Date: 20th December 2019

Our Ref: PAA/131/19/

Pre-Application Advice

New bungalow.
White Lodge Hangleton Lane Ferring

Proposals 01

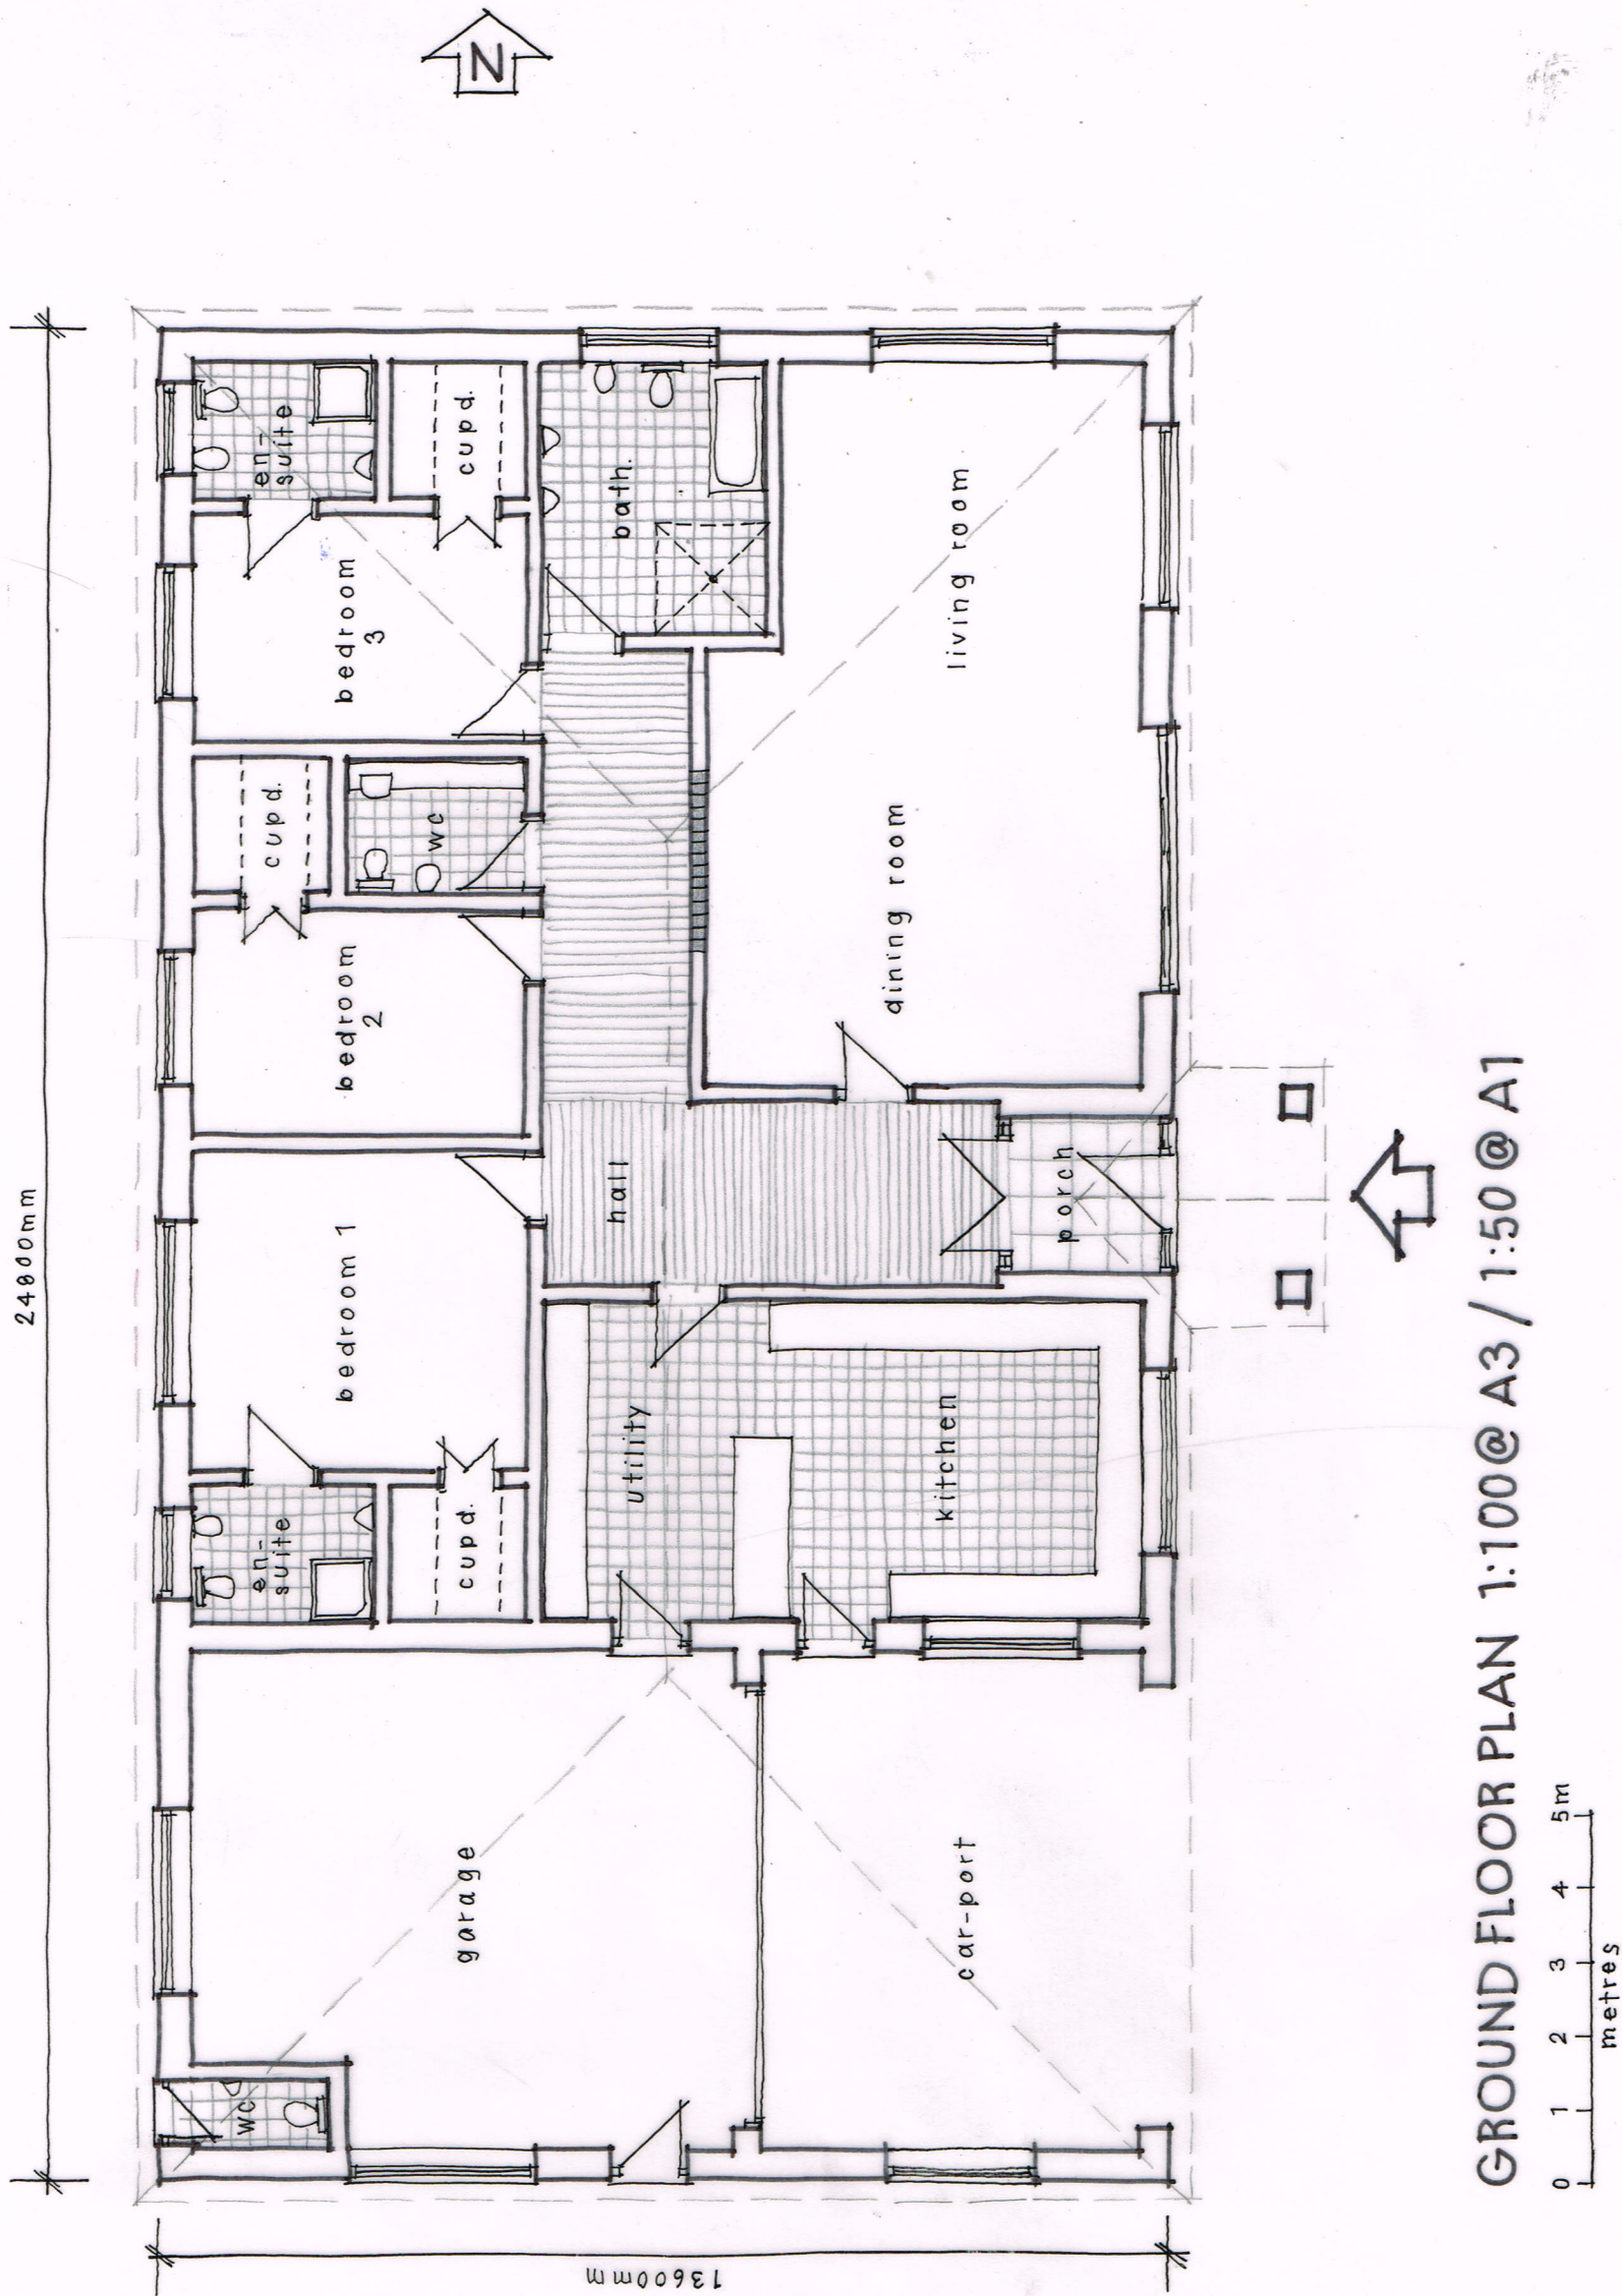
The plans indicate the property would have a GIA (not including the garage/car port) of around 221sqm. This would exceed the national minimum internal space standards and would comply with policy in this respect. The plans also show that at least 2.5sqm of built-in cupboards would be provided as required by the standards. The accommodation appears to be well-laid out and the proposed position and size of window/glazed door openings would provide the rooms with decent outlook and natural light.

The plans indicate that the new dwelling would have a small rear garden and a large lawn to the front of the property in front of the driveway. This would be of ample size and would be commensurate with the size and type of dwelling and character of the area. It is suggested that at least part of this area should be enclosed to provide suitably private outdoor amenity space, and details of proposed boundary treatment would be required at application stage.

No specific bin storage details have been provided on the plans. Any future application would need to include details of bin storage/collection provision as per the above requirements and would need to show a bin collection point at or near the highway boundary, to ensure it allows for kerbside collection.

The plans indicate that the 3 bedroom house would have an integrated double car port - whilst each of the spaces inside would be 3m wide, which meets the requirements of the ADC Parking SPD, they would only be around 4.5m in length so would not meet the SPD requirements for 6m in length. As such, this would only count as 1 parking space (parking width-wise) rather than 2. The double garage would provide 2 spaces which would internally be 3m wide and 7.5m which would meet the SPD requirements. However, as stated in the emerging SPD, since garages are often used for storage, a garage is only counted as 0.5 of a space. As such, this would only count as 1 parking space. In total, according to the parking standards, there would therefore be 2 parking spaces provided within the car port and garage. There would also be parking for at least two vehicles on the front driveway. As such, the proposals would provide sufficient on-site parking provision.

No specific cycle storage details have been provided on the plans. Any future application would need to include details of this as per the above requirements, with cycle storage being undercover and secure.

NEW DWELLING AT
WHITE LODGE, HANGLETON LANE
FERRING
Proposals 02
Feb 2020

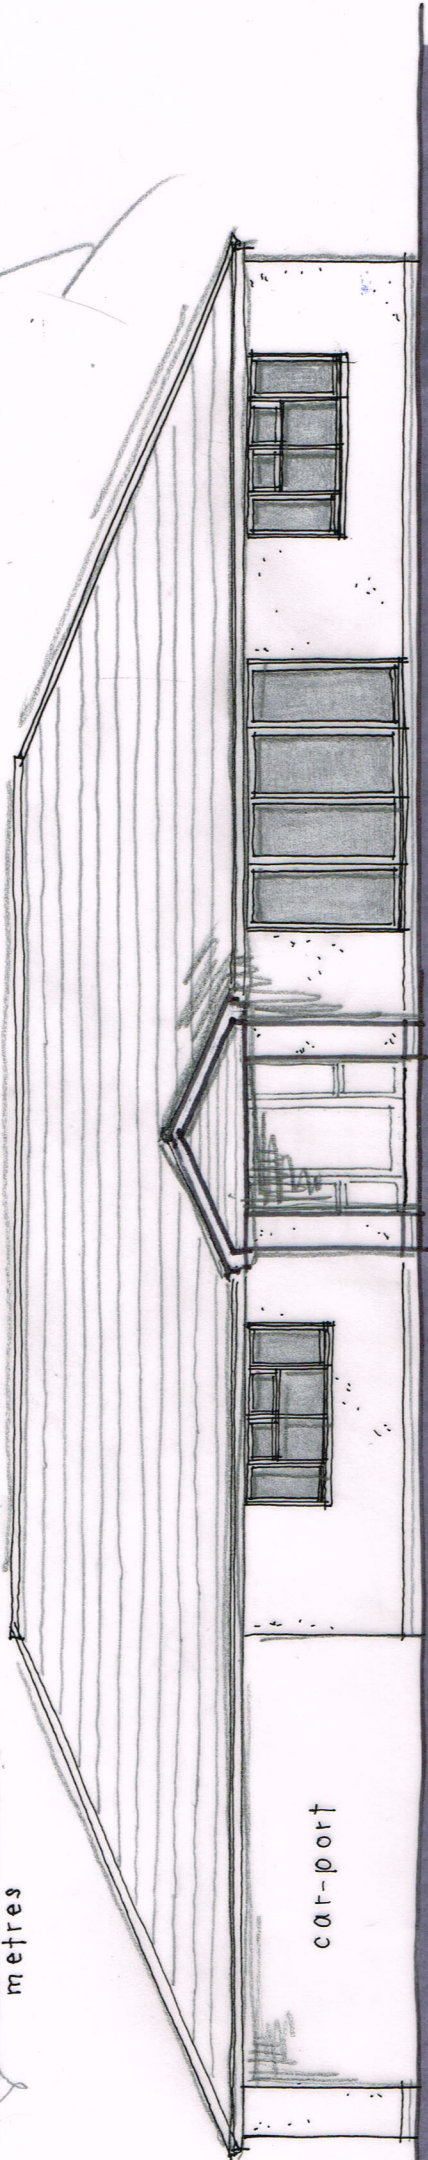
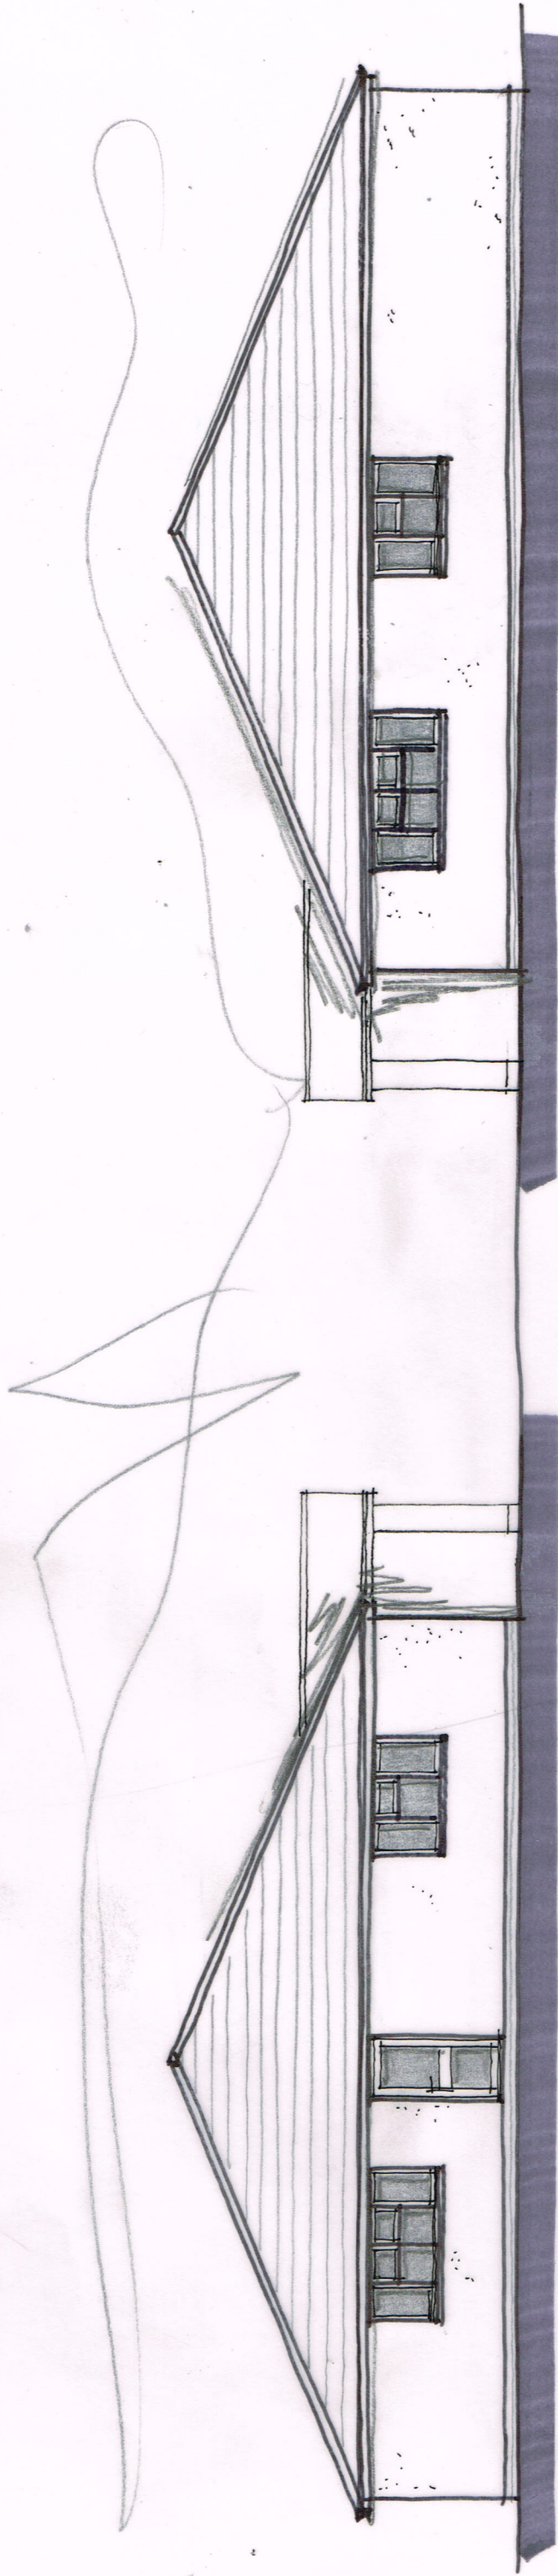
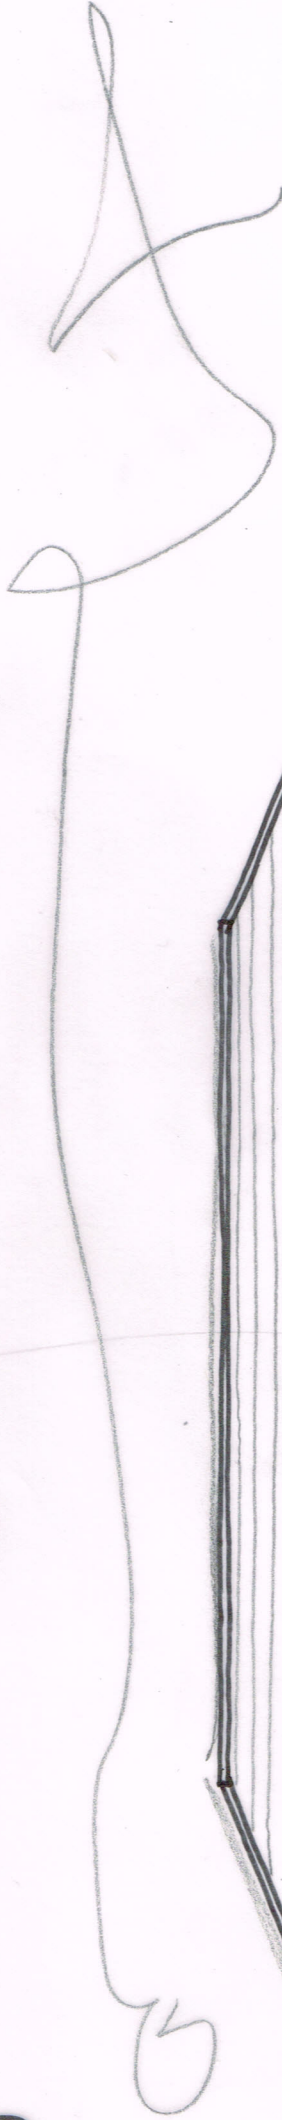
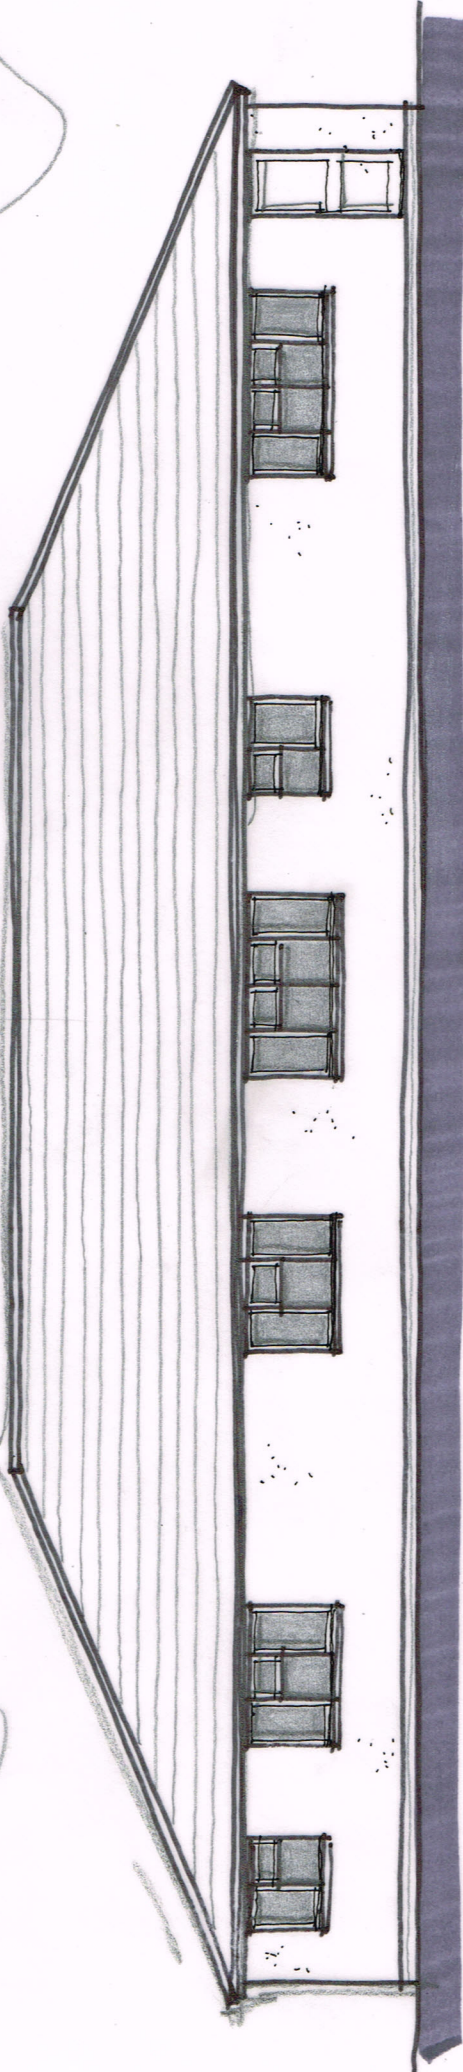
The proposed hipped roof form would be sympathetic to the roof form of the main house and annexe and some of the nearby properties. The ridge height of the roof would be very high (7.4m) and the pitch steep for a single storey bungalow with no roof level accommodation. It may be preferable if the height were reduced to make the dwelling more low-profile. However, given its limited visibility and that the existing dwelling on the site 'White Lodge' is a chalet bungalow with a similar roof height to that being proposed, this aspect would be unlikely to be considered visually harmful if an application were to be forthcoming.

It is noted that the addition of any roof level accommodation e.g. dormer windows etc. could result in significant overlooking and loss of privacy into this neighbouring property and its gardens. As such, the applicant would be advised against this in any future scheme design.
